East Anglia ONE North Offshore Wind Farm

Appendix A12 to the Natural England's Deadline 4 Submission

**NE advice on Red-Throated Divers in the Outer Thames Estuary Special
Protected Area related to Deadline 3 submissions**

Planning Inspectorate Reference: EN010077

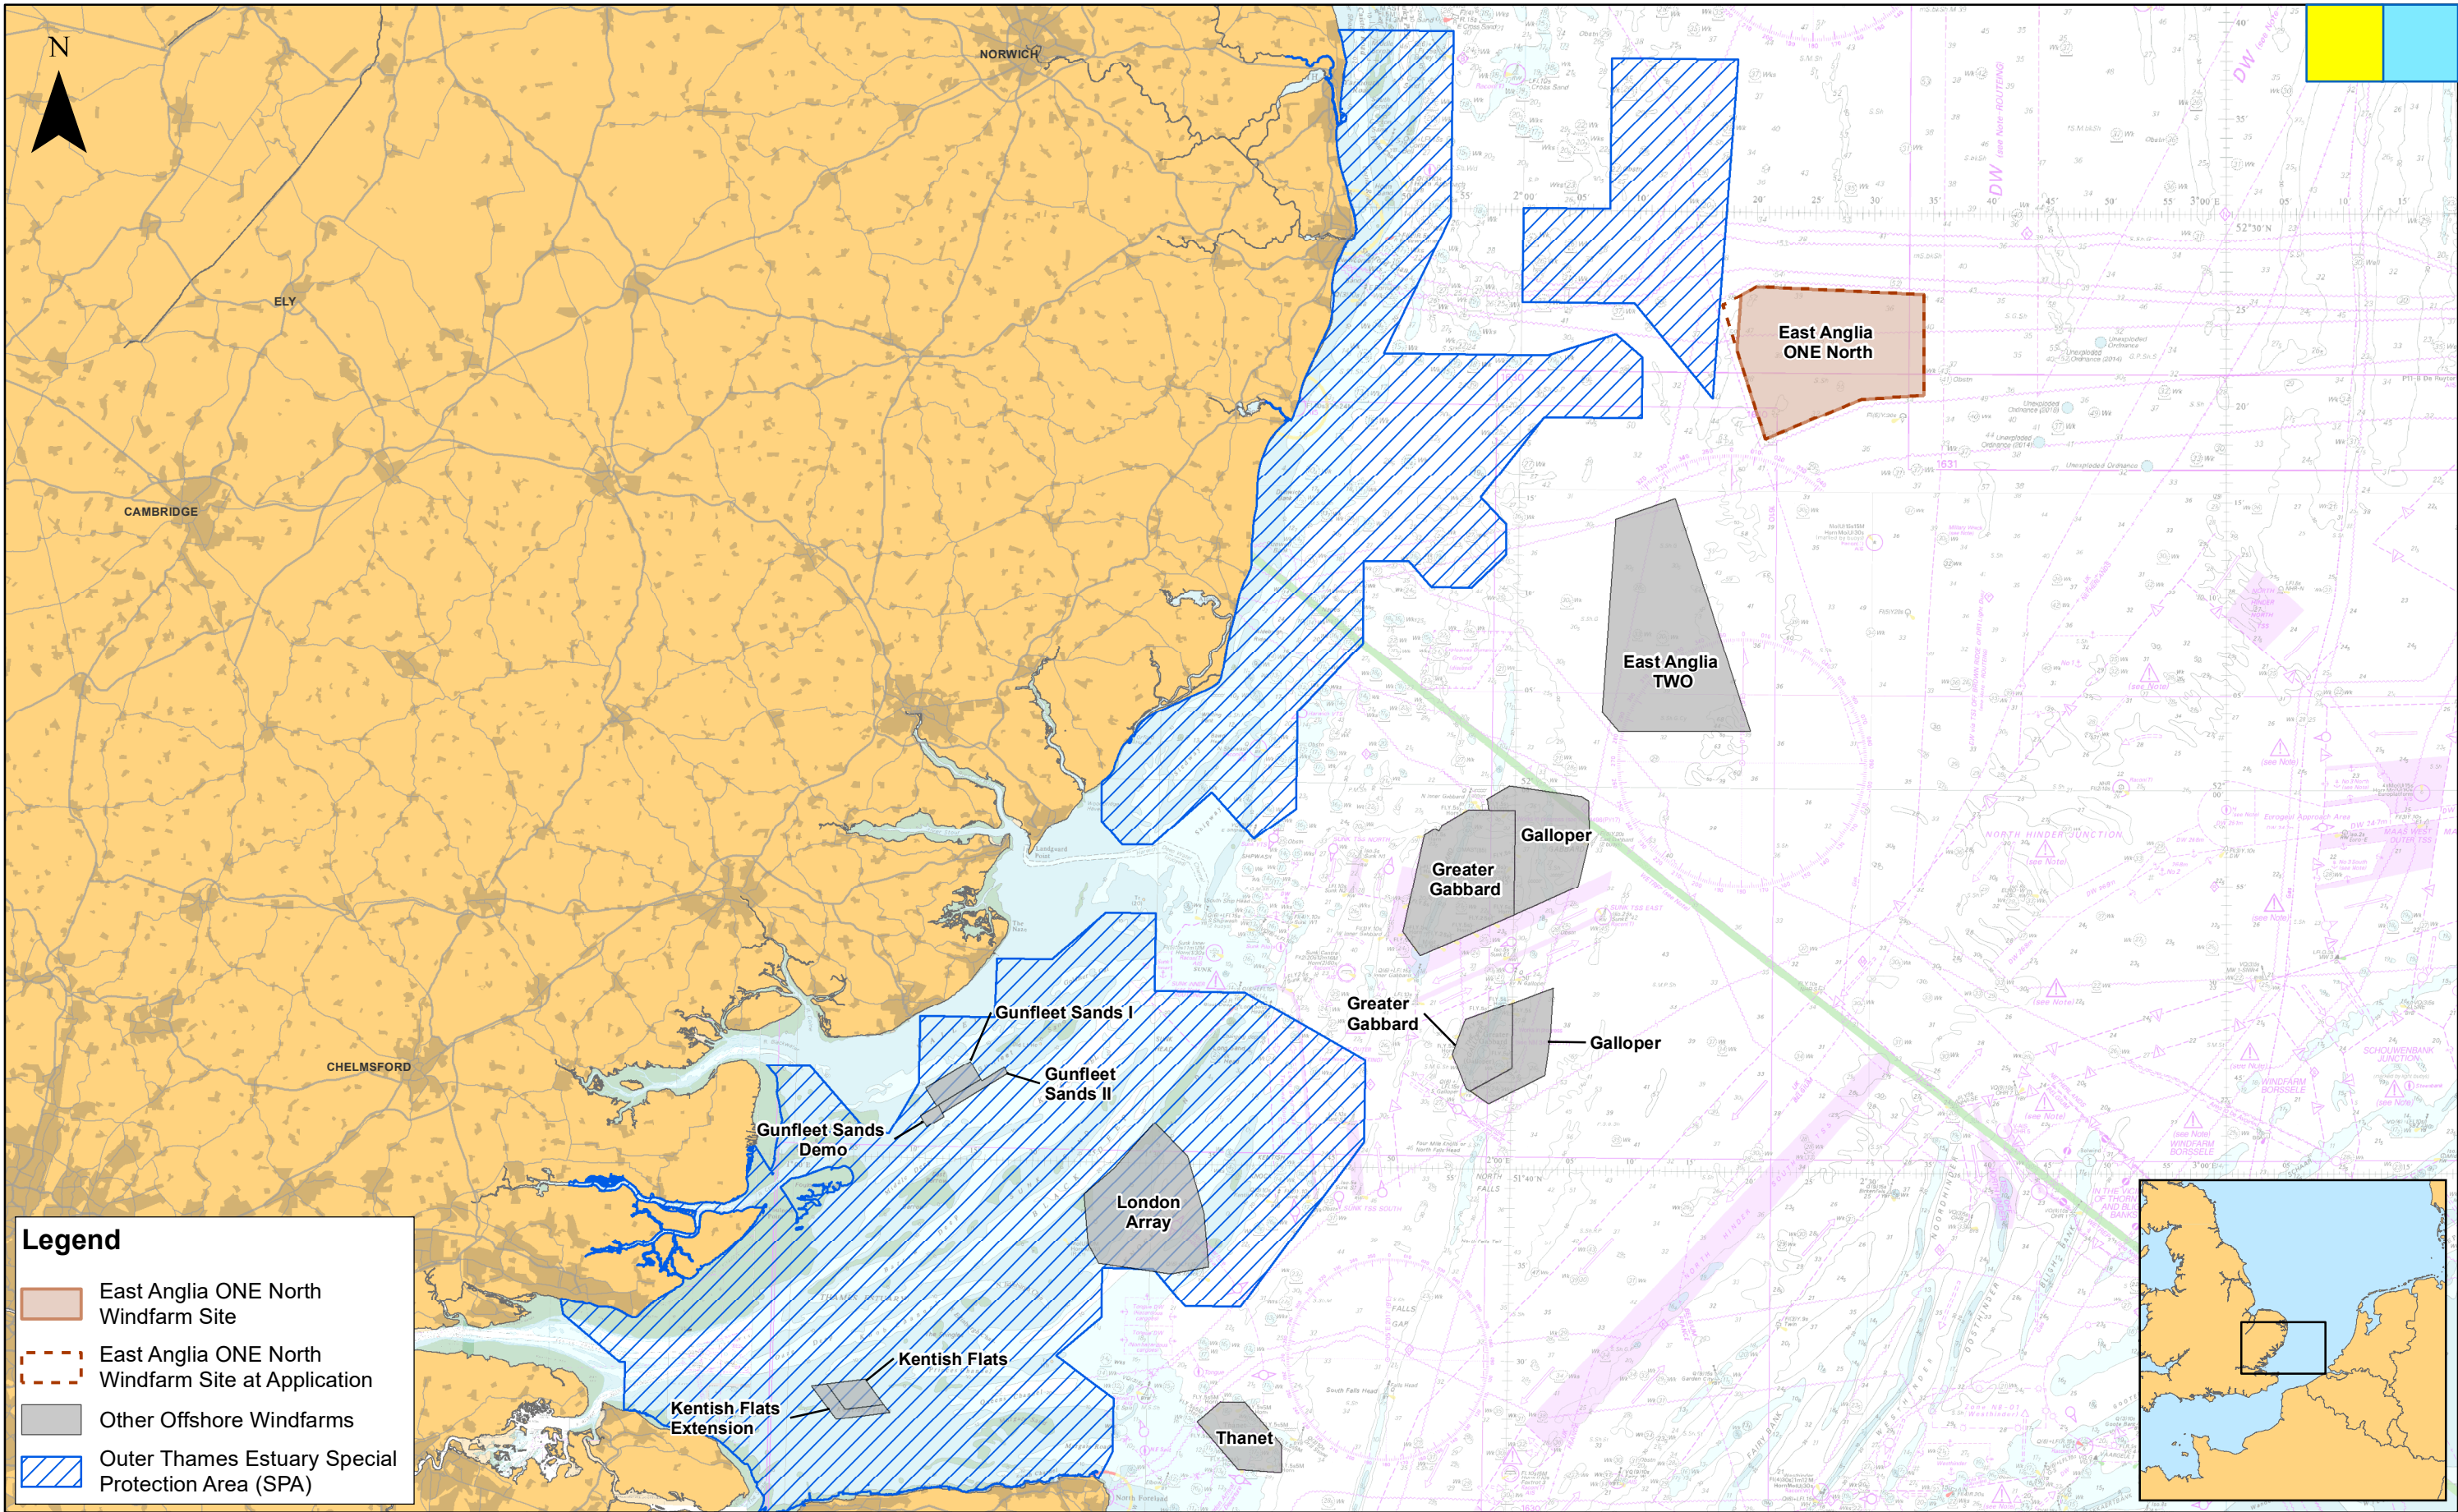
4. Adoption of 2km buffer: Natural England welcomes the Applicant's commitment to the provision of a 2km buffer between East Anglia One North and the SPA boundary. However, we note and agree with the Applicant's position that the 2km buffer reduces the impact, but the proposed buffer does not fully mitigate the impact of displacement to an acceptable level.

5. Locating OWFs away from RTD SPAs: We also acknowledge that there will not be complete avoidance within the buffer, instead there is a gradual decline in displacement with increased distance from the windfarm. However, whether the displacement is 7km, as proposed by the Applicant's modelling, or 11.5km as predicted by the London Array monitoring, **the area affected is significant.** The advice in: "*Review of ornithology constraints for Offshore Wind Leasing in Areas 3 (Yorkshire Coast) and 4 (The Wash)*" Report to The Crown Estate (March 2019) by MacArthur Green states:
